# PLAN SNAPSHOT REPORT MINOR\_PLT-2026-00022 FOR CITY OF ALBUQUERQUE

**Description:** Adjust common lot line between Lot 2 & 3, Block G, Altura Addition.

**Project Number:** PR-2025-020158

**Project Name:** 1619 Solano Dr. NE

SKETCH PLAT FOR
LOTS 2A & 3A, BLOCK G,
ALTURA ADDITION
SITUATE WITHIN
SECTION 14, T.10 N., R.3 E., N.M.P.M.
CITY OF ALBUQUERQUE
BERNALILLO COUNTY, NEW MEXICO
NOVEMBER 2025

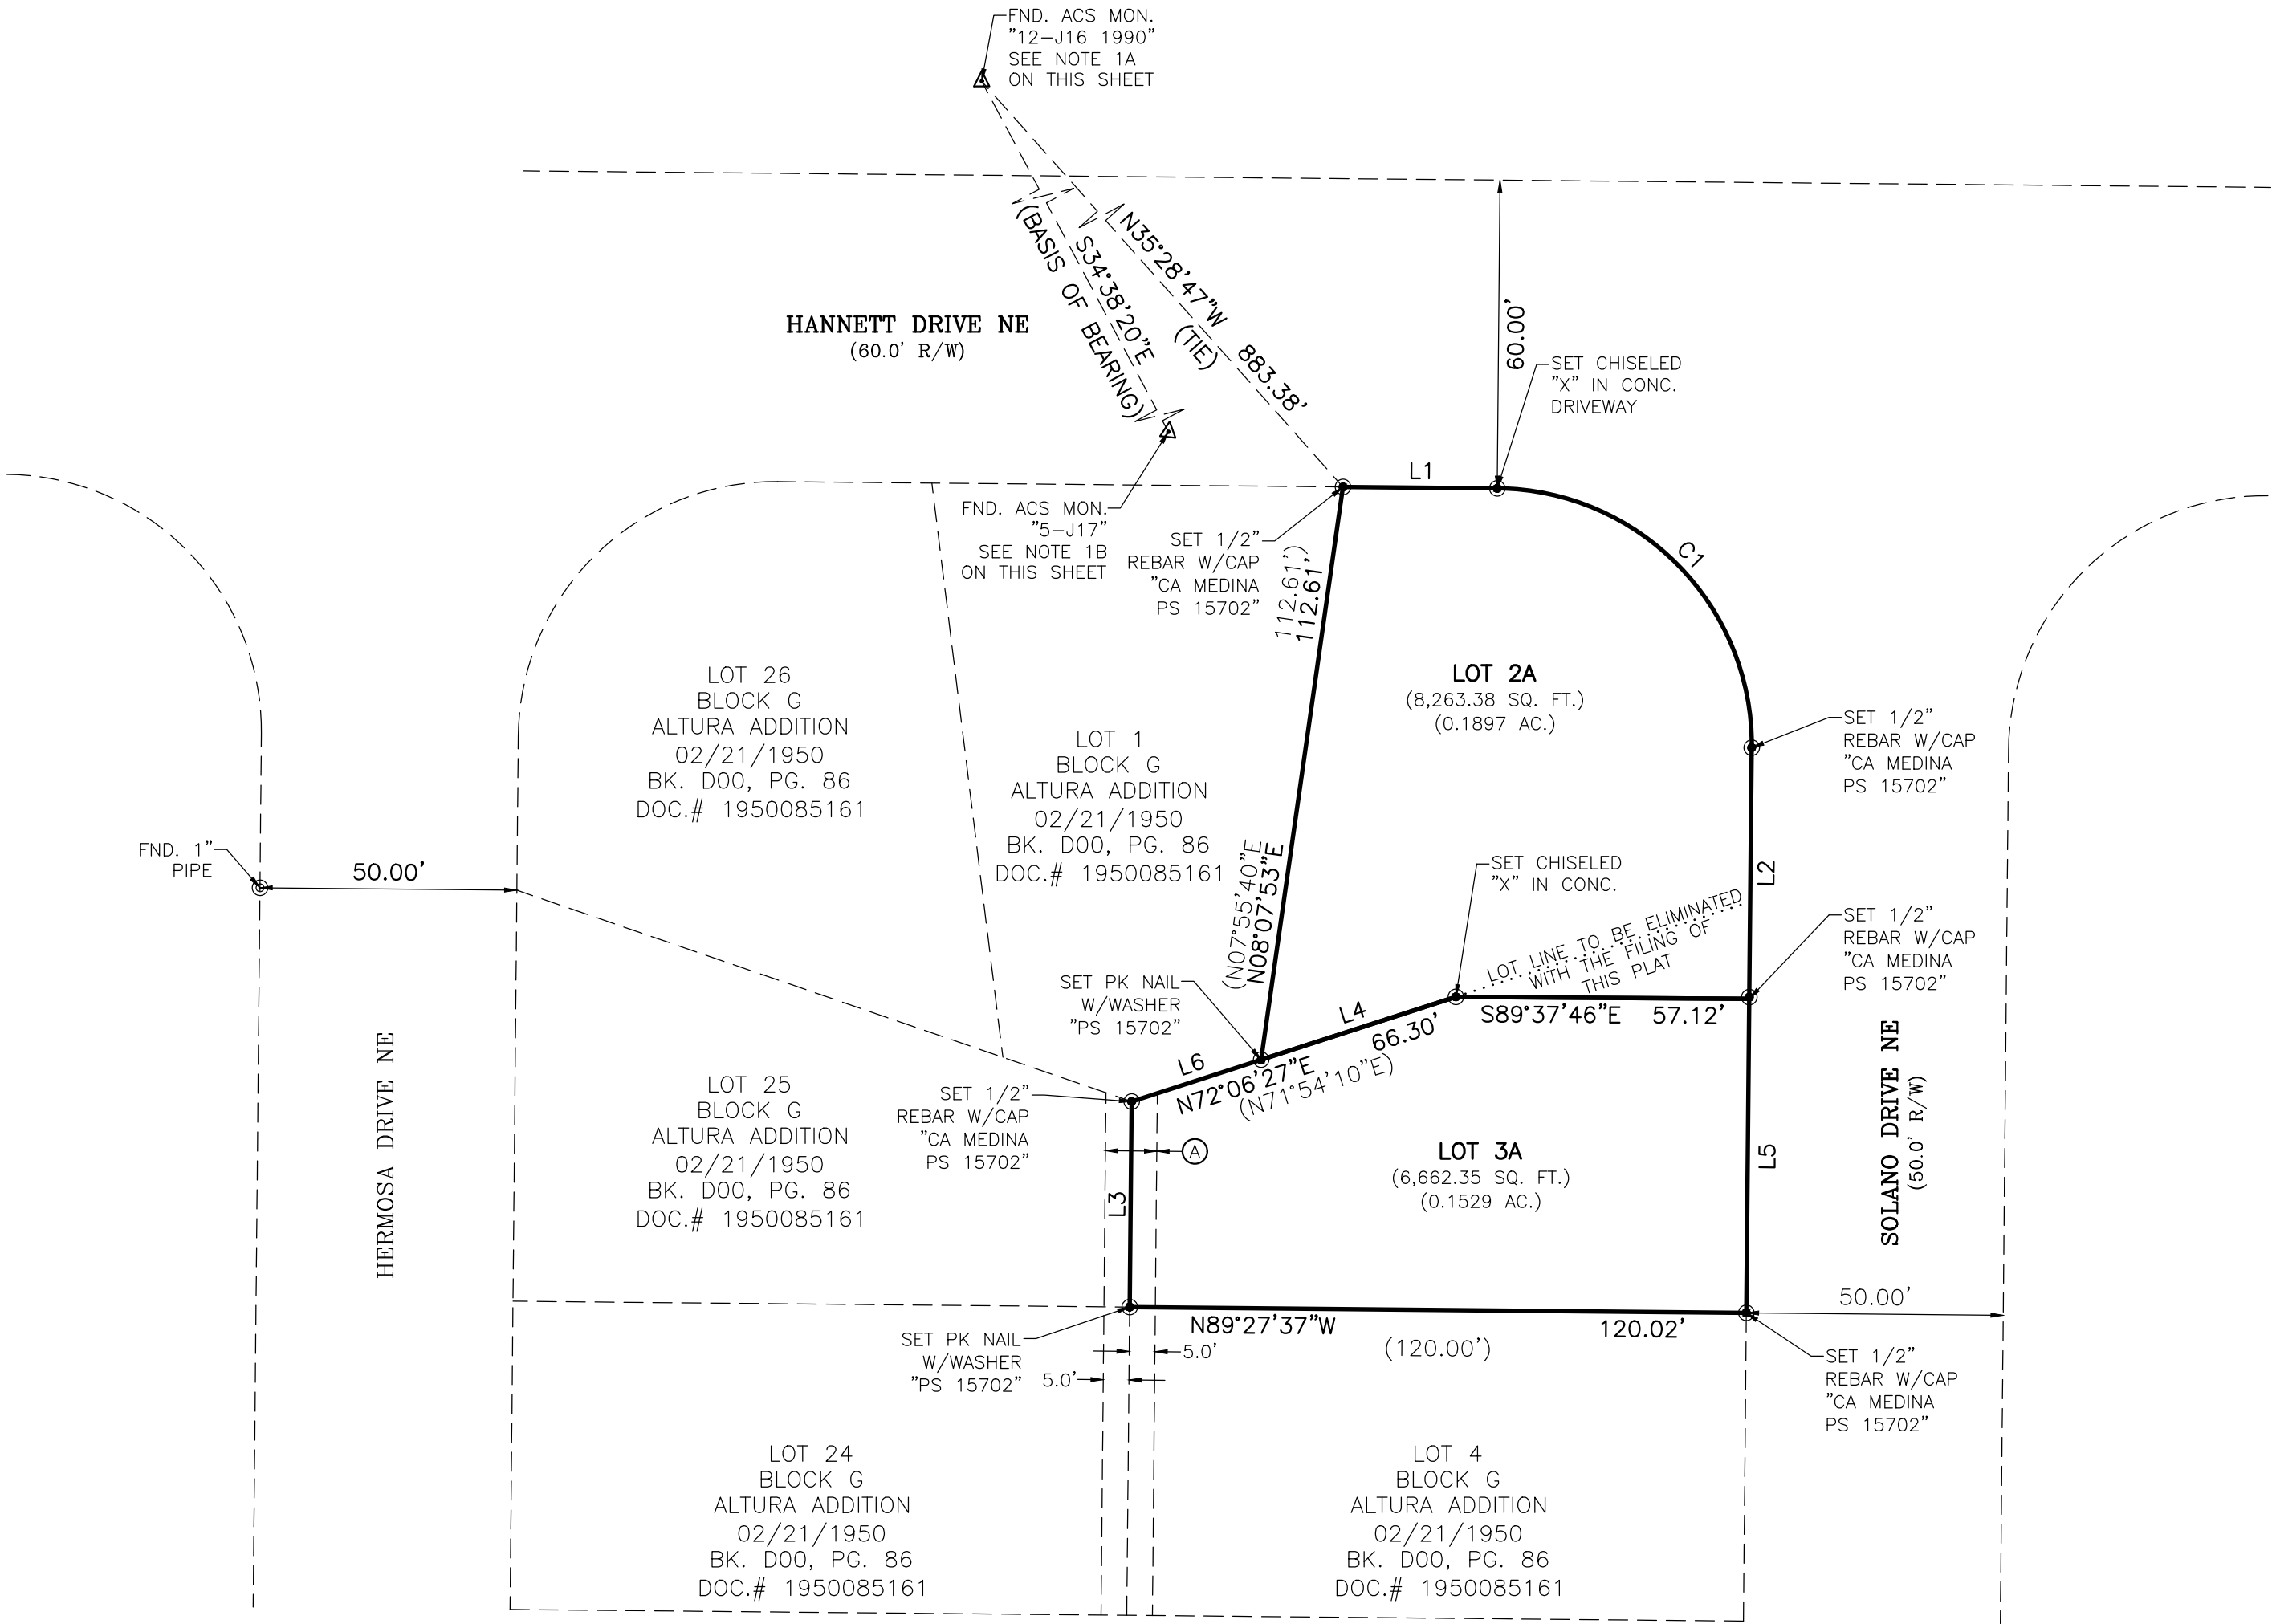
- The subject property is zoned R-1B (Residential – Single-Family Zone District) and falls within the Altura Addition Neighborhood Association.
- Demonstrate compliance with Section 7 of the **DPM, Table 7.2.29**, regarding Sidewalk width requirements and its landscape buffer. Both Solano Drive and Hannett Avenue NE are considered Local Streets and require a 5ft sidewalk width and a 4-6ft landscape buffer.

Comments from the sketch plat indicated that a 5' wide sidewalk would be required along both Hannett Ave NE and Solano DR NE. Since the property owner is currently renovating the dwelling unit on Lot 2, the applicant opted to remove and replace the existing sidewalks and replace them with 5' wide sidewalks, to meet the requirements of the DPM. The application includes photos of the sidewalks showing a wider sidewalk including the area adjacent to an existing fire hydrant. No other infrastructure improvements were required; therefore, an infrastructure list was not provided.
